25 February 2024

**RE: PLANNING SUBMISSION IN RELATION TO THE STATE SIGNIFICANT DEVELOPMENT APPLICATION
– SSD-35631707 – TELSTRA EXCHANGE SITE, ST LEONARDS**

PROPERTY AT: 524-542 PACIFIC HIGHWAY, ST LEONARDS

Figure 10 *AMA House to the south of the site*

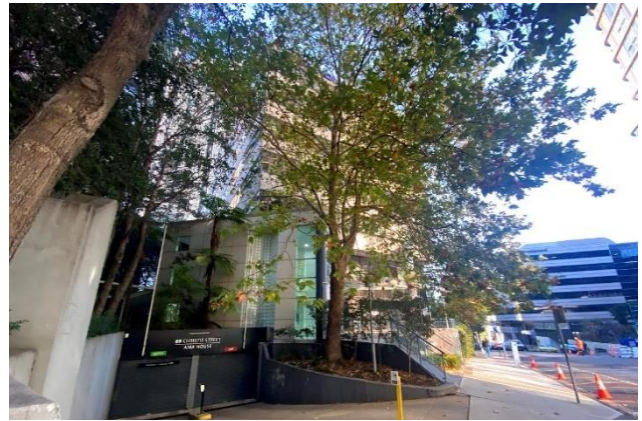
- Council should consider the extent of overshadowing that would occur to particularly, AMA House located adjacent to the South of the Site. This Site would be heavily impacted at all times of the day.

- For example, should the site known as AMA House be developed to its maximum height of 24 storeys under the *St Leonards and Crows Nest 2036 Plan*, assuming each storey is 3m floor to floor, the resultant building has the potential to be 72m.

- The *EIS* notes that it has only contemplated the AMA House site to be a maximum of 36m.
 - The proposed building includes dwellings to be located within this area and provides a 0m setback to the southern boundary with AMA House.

- Numerous building interference issues could be caused by this that have not been mentioned or considered in the design or accompanying reporting of SSD-35631707.

Figure 33 Proposed eastern elevation

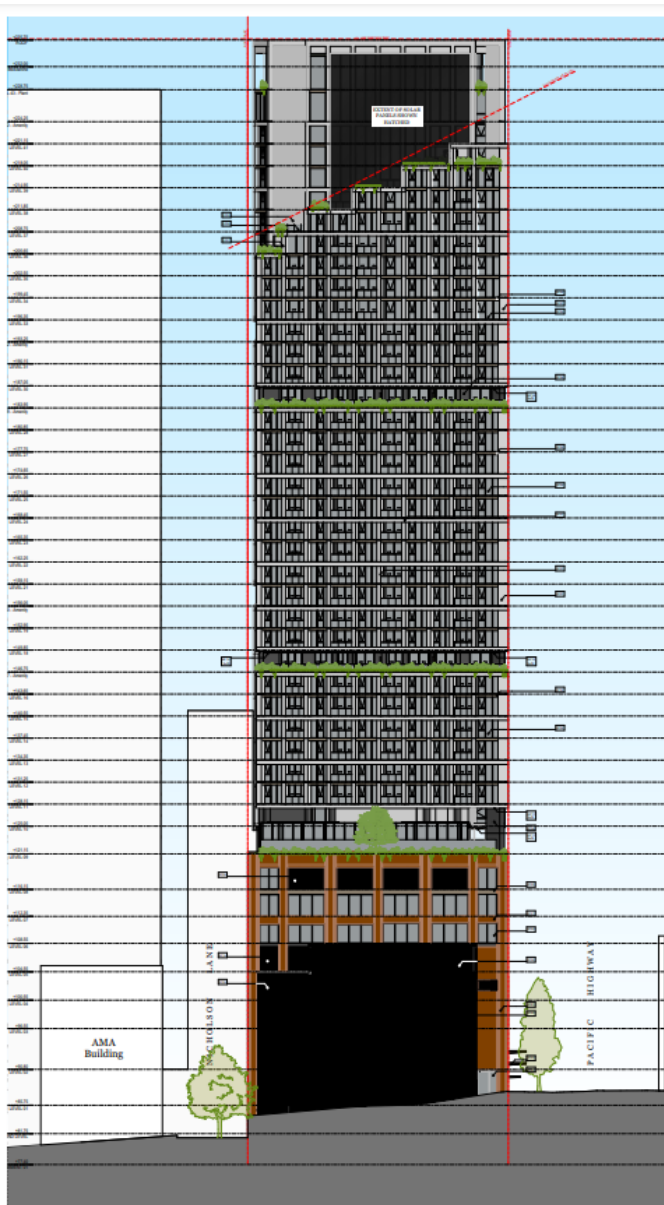
- The DPHI should consider the height, bulk and scale of the proposed development, and if further architectural treatment and articulation is required. The southern elevation is to be particularly considered, as there will be prominent views to the Site of this elevation. A review of the Architectural Drawings indicate that the proposed building is not satisfactorily integrated with the bulk and scale of the adjoining buildings.

Figure 34 Proposed overshadowing to Newlands Park on the 10:05am solar plane

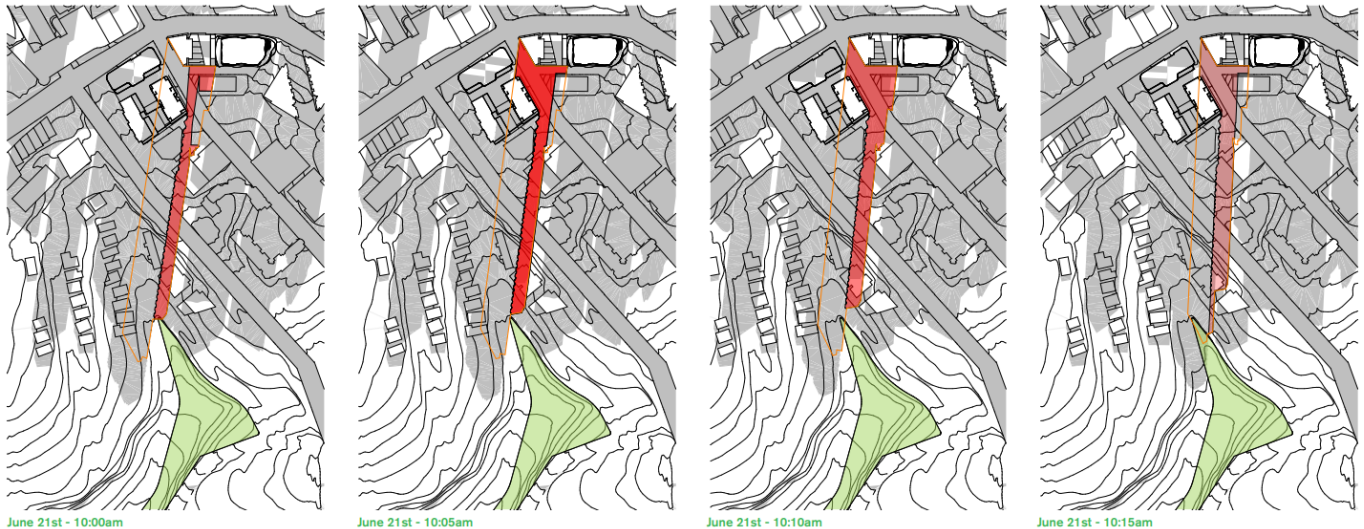
- The shadow diagrams located within the Architectural Drawings indicate the proposed development would result in significant overshadowing increases.
- Section 7.2.1 of the EIS considered overshadowing of Newlands Parks.
